Gatwick Airport Northern Runway Project

Examination Ref: TR020005

Supporting Noise and Vibration Technical Notes to the Statements of Common Ground - Book 10 – Version 1- April 2024 – Document reference 10.13 [REP3-071] Review

Deadline 4: 15 May 2024

Appendix 2: Slow Transition Fleet Noise Contours

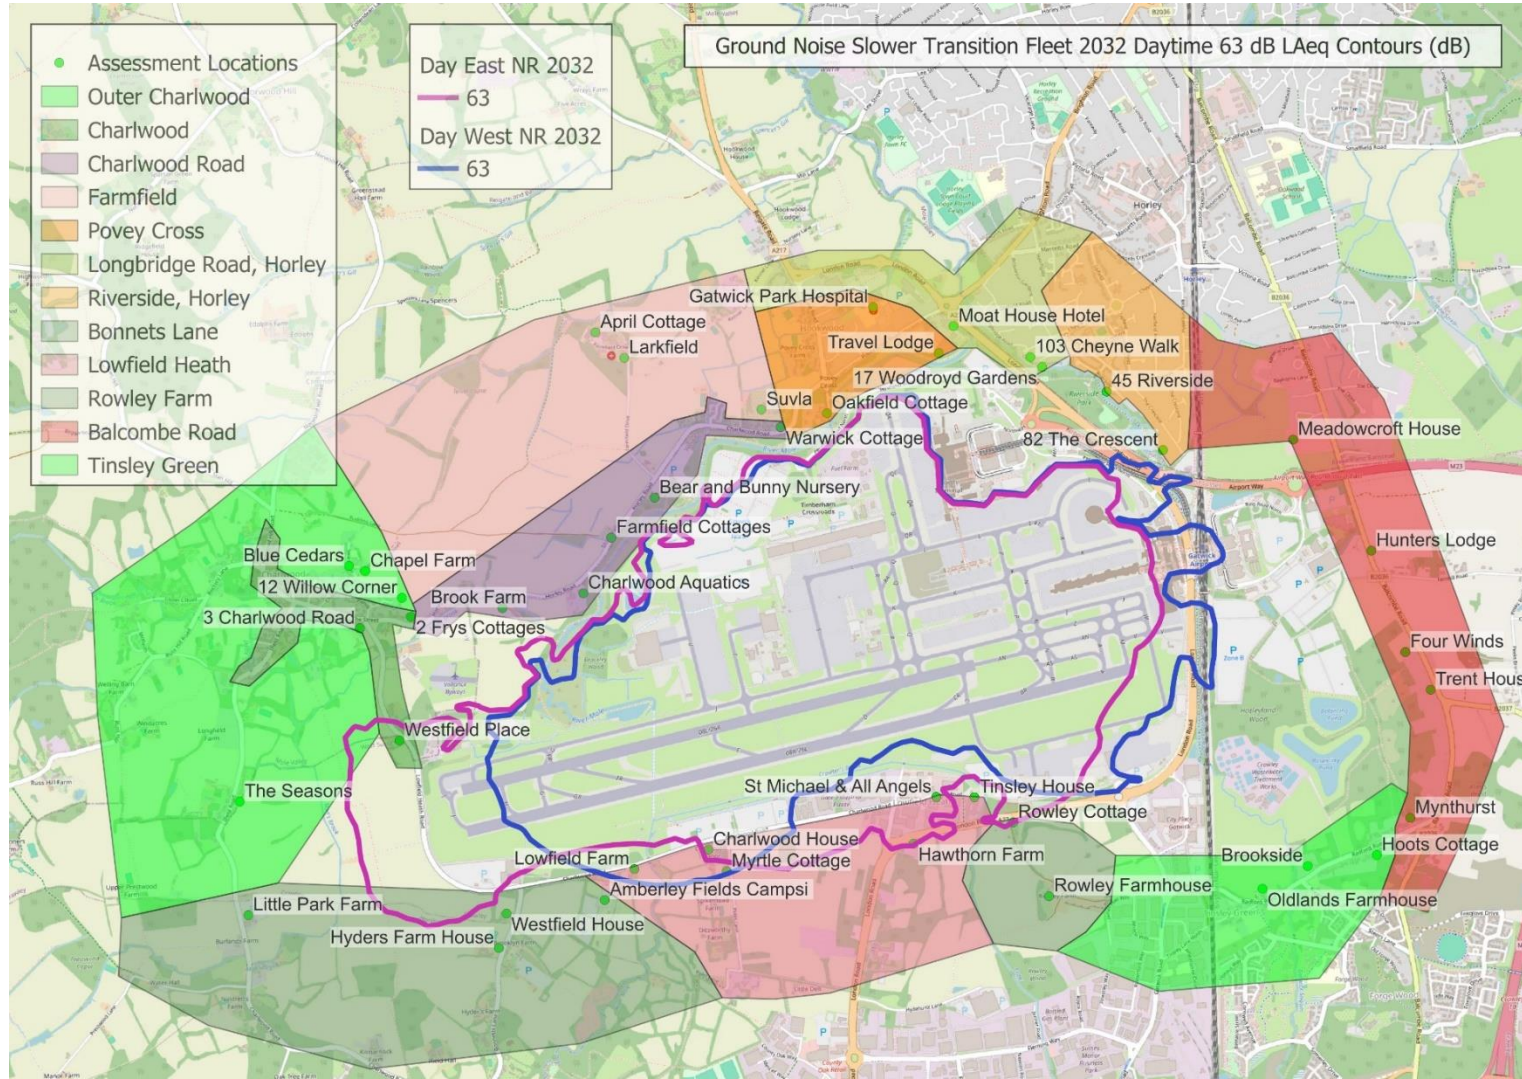
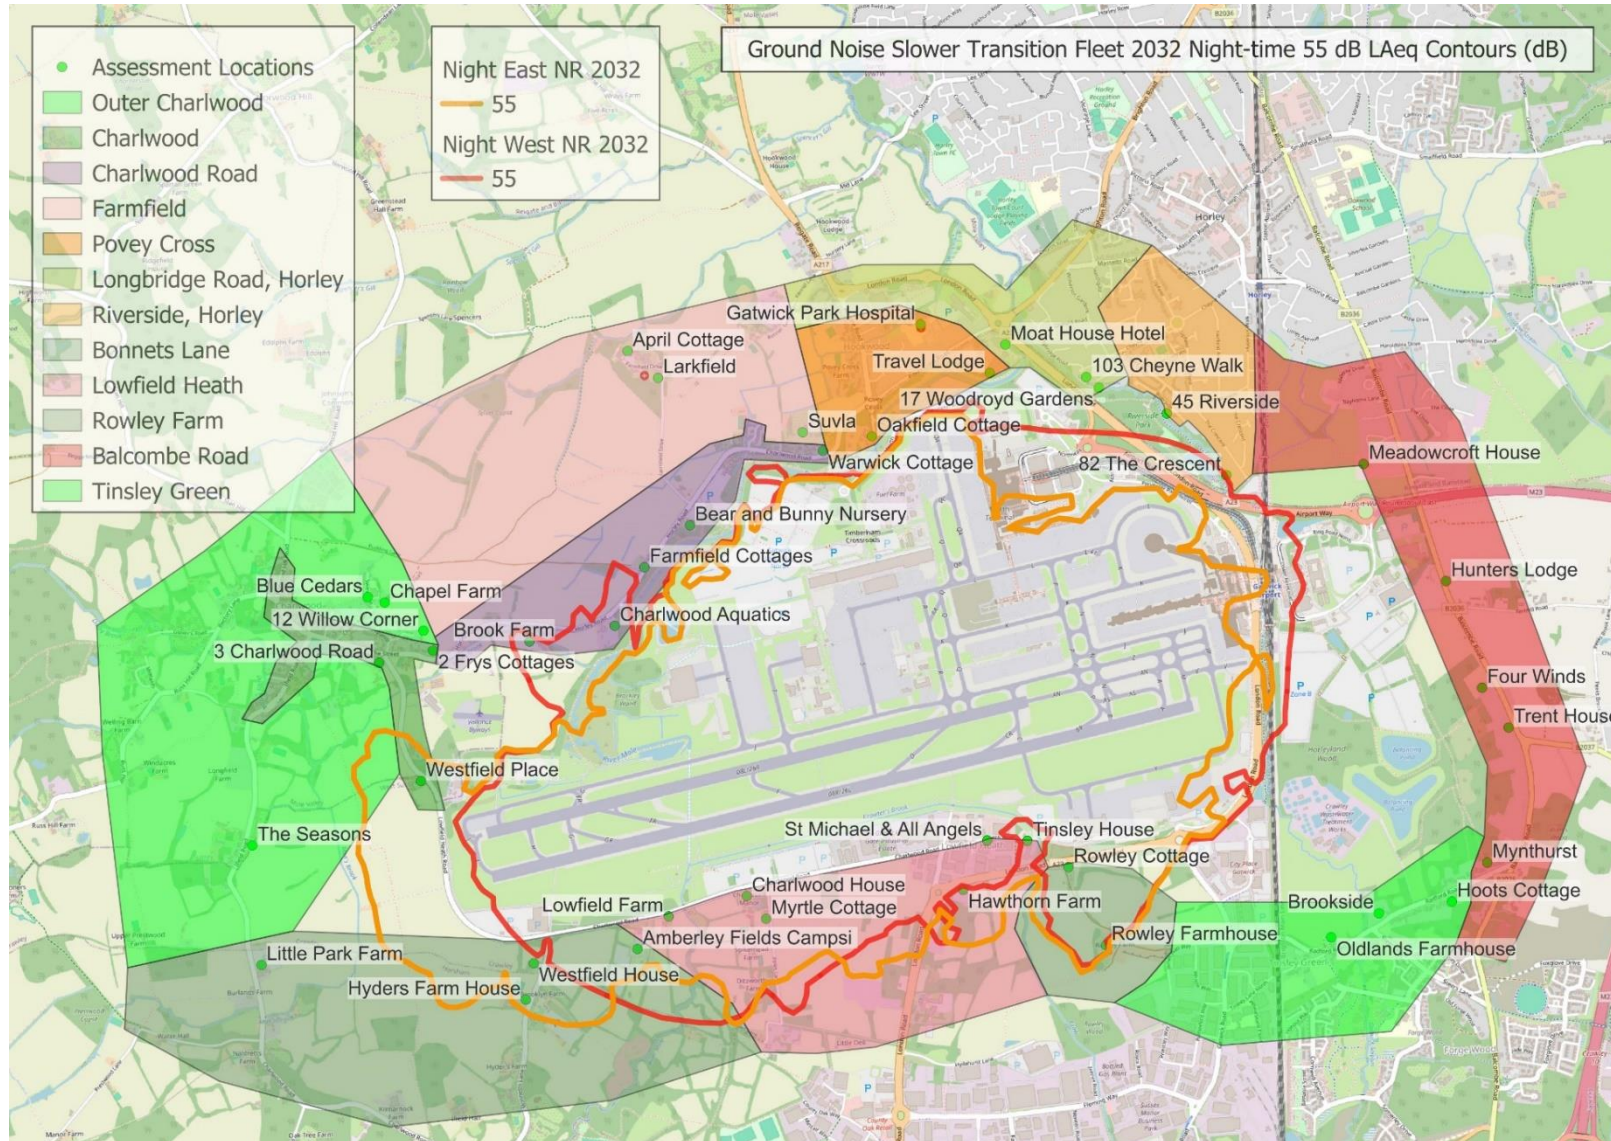
JLA-NVTN-B3	1.1.5	Ground noise contours	<p>The ground noise contours provided are not adequate for determining how communities would be affected. The contours should be presented, as per air noise, in 3 dB increments from 51 dB daytime and 45 dB night-time so the JLAs are able to identify noise sources and how effective mitigation is.</p> <p>They should be provided with a zoomed in view and a better resolution of base-mapping so properties can be identified.</p>

Ground noise contours for all assessment scenarios should be provided.
JLA-NVTN-B3	2.1.1	Comparison of future operational scenario with future baseline	The assessment only looks at the change in noise between the operational scenario and the respective future baseline. As per the air noise assessment, likely significant effects should be identified for smaller changes in ground noise when the SOAEL is exceeded.
JLA-NVTN-B4	3.1.2	Ambient noise sources	The Applicant states that existing sources of noise, such as road traffic noise, are a factor in the ground noise assessment are not discussed in the ground noise assessment in ES Chapter 14: Noise and Vibration [APP-039] . As stated in, JLA-NVTN-B2, the JLAs request that the ES chapter is updated with tracked changes.
JLA-NVTN-B5	3.1.4	Complaints	The Applicant states that the lack of complaints is reason for not identifying ground noise as a major concern. The JLAs are of the opinion that there is no basis for this assumption as complaints only tend to be made about unusual events and typical activities can still cause disturbance even though a complaint is not made.
